Rezoning Transportation Analysis

Petition Number: 2020-45

General Location Identifier: Parcels 09104101, -02, and -03 on Bearwood Ave.

**Bearwood Ave
Rezoning Site Plan**

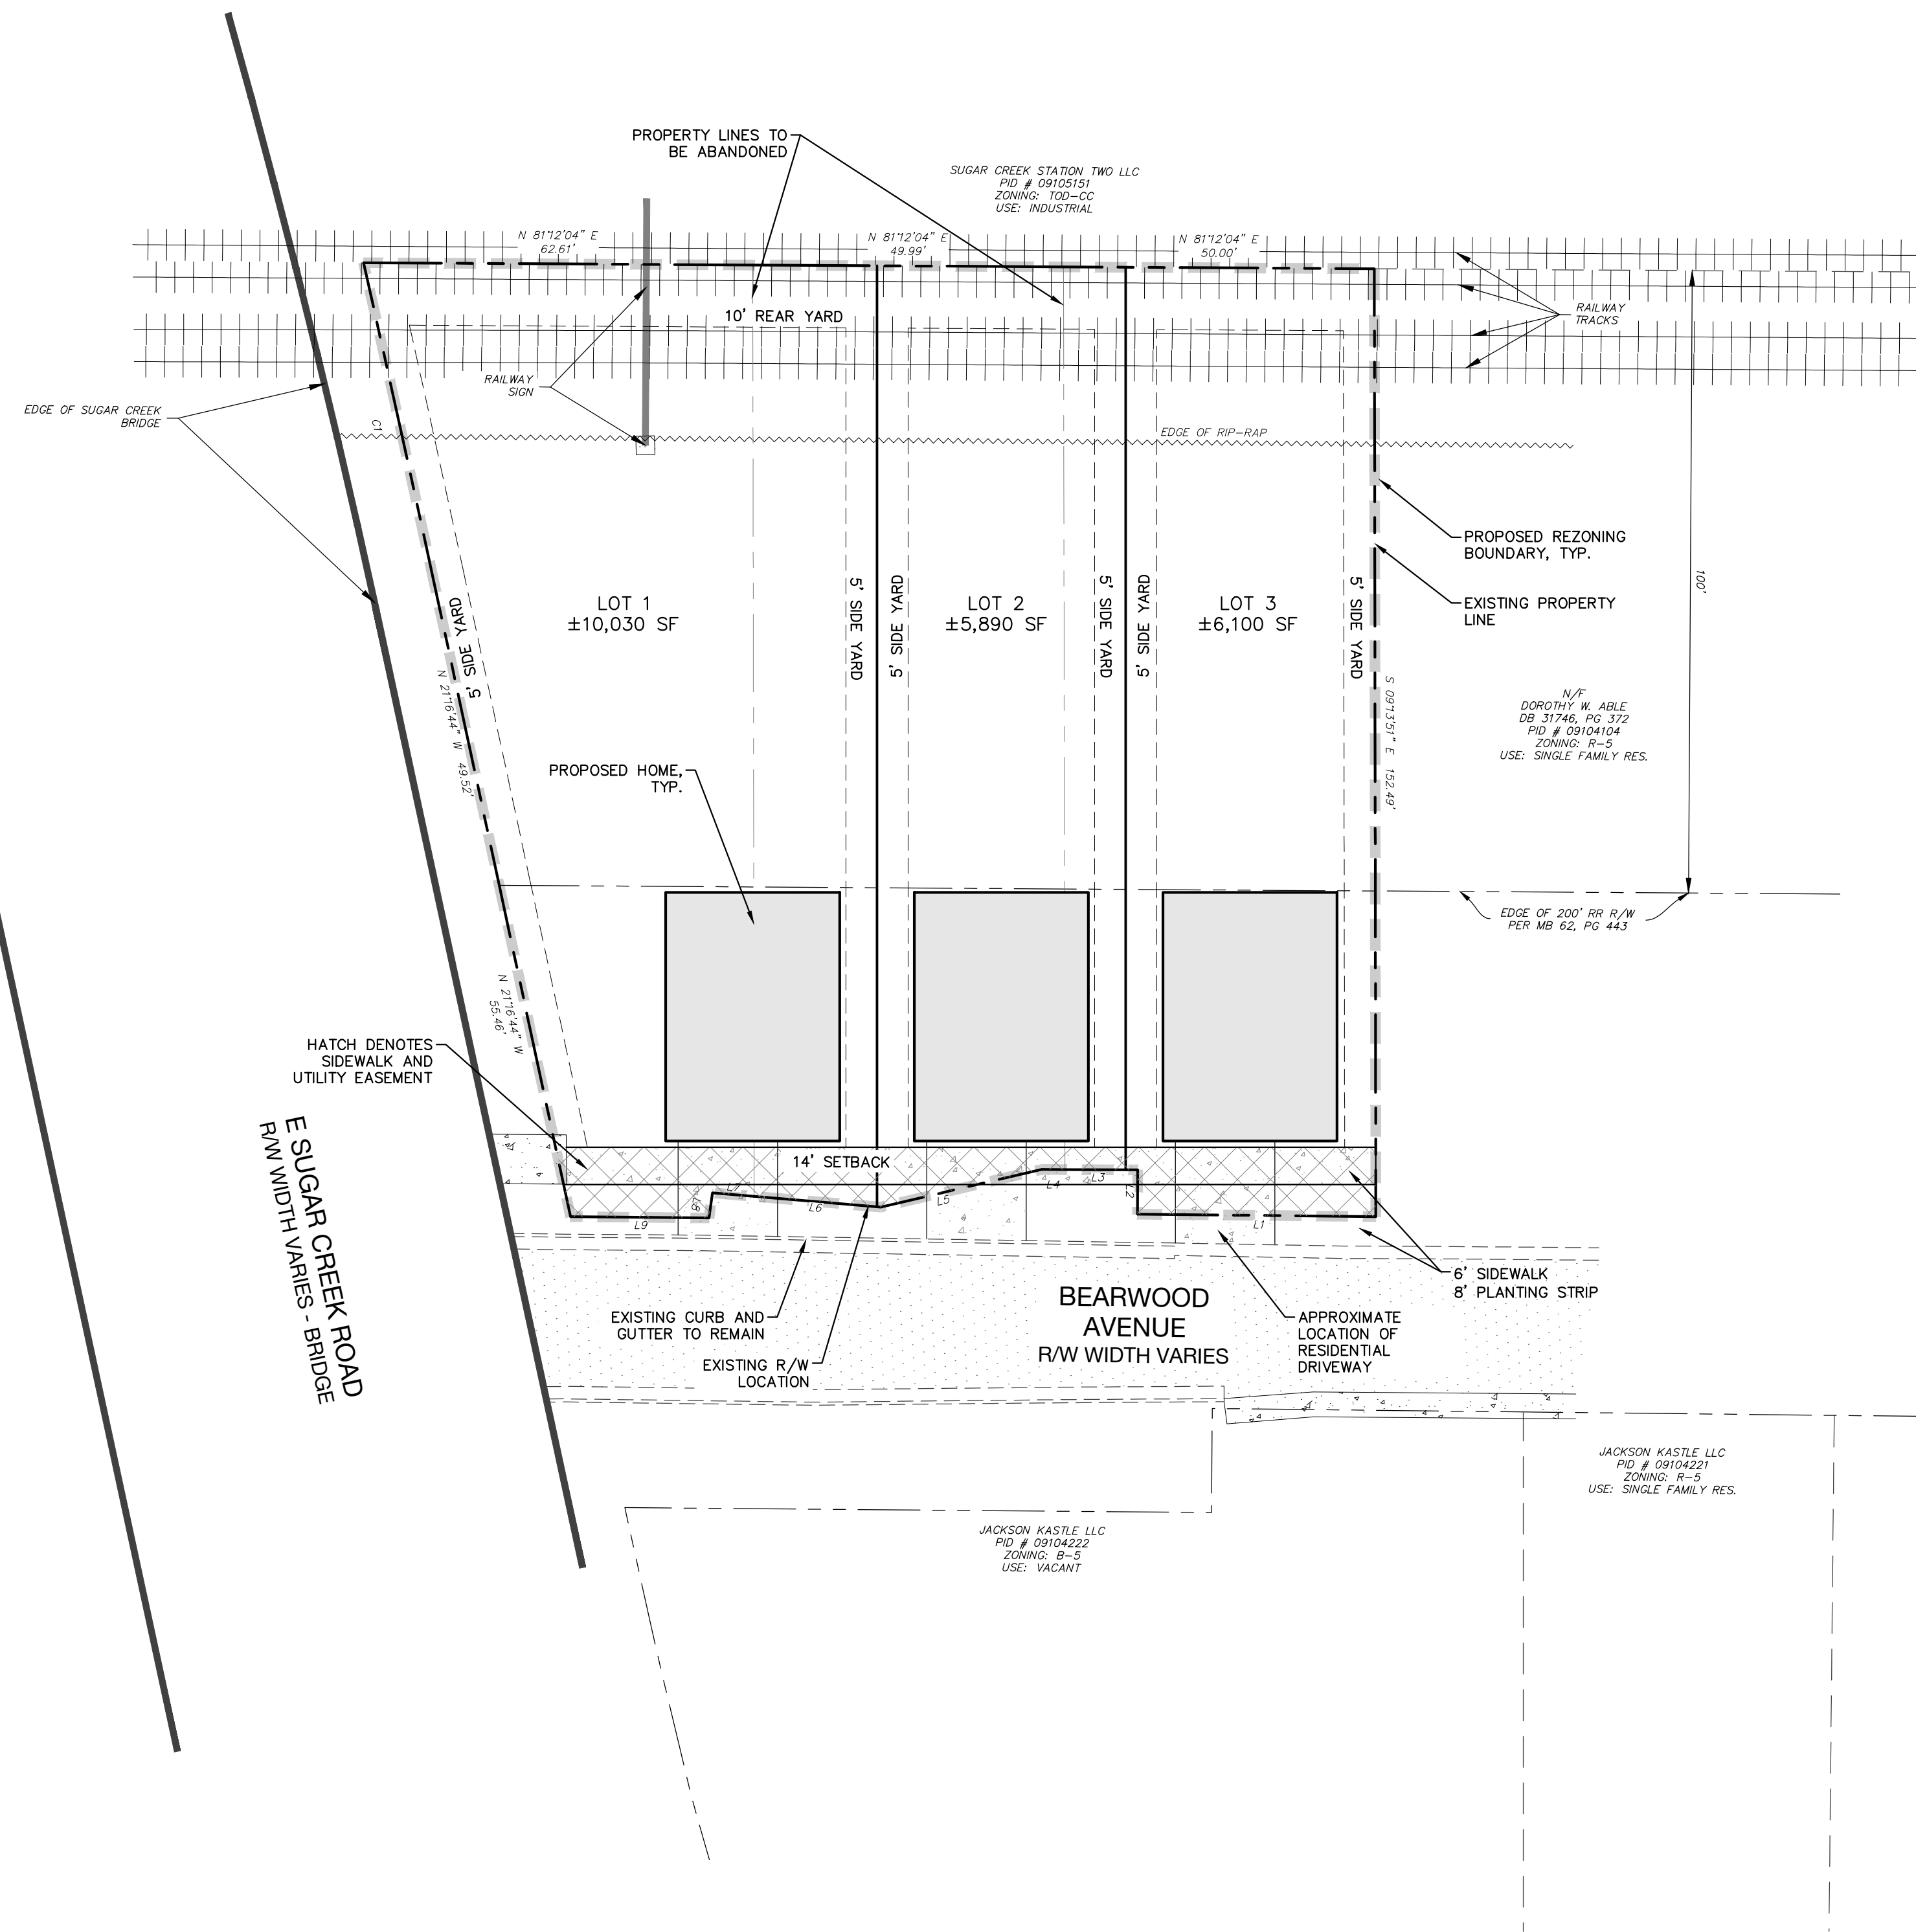
The site plan should show the curb and gutter labeled and dimensioned from the centerline for each road.
- Traffic Study** A Traffic Impact Study is not necessary for the complete review of this petition. If during the permitting process the site generates more than 2,500 daily trips, then a traffic study will be required.

- The right-of-way line for Bearwood Ave. should be revised to be a consistent dimension from centerline.
- The petitioner should revise the site plan and conditional note(s) to adjust the proposed building footprints to ensure that there is a minimum of 20 feet from the garage to the back of sidewalk or back of right-of-way, whichever is greater, as required by the Zoning ordinance. If the railroad right-of-way precludes adjustments to building footprints, suggestions for providing parking include providing shared parking in the rear of Lot 1, and providing recessed parallel parking on Bearwood Ave.

- The petitioner should revise the site plan to add a note specifying dedication and fee simple conveyance of all rights of way to the City before the site's first building certificate of occupancy is issued. CDOT requests right of way set at 2' behind back of sidewalk where feasible.
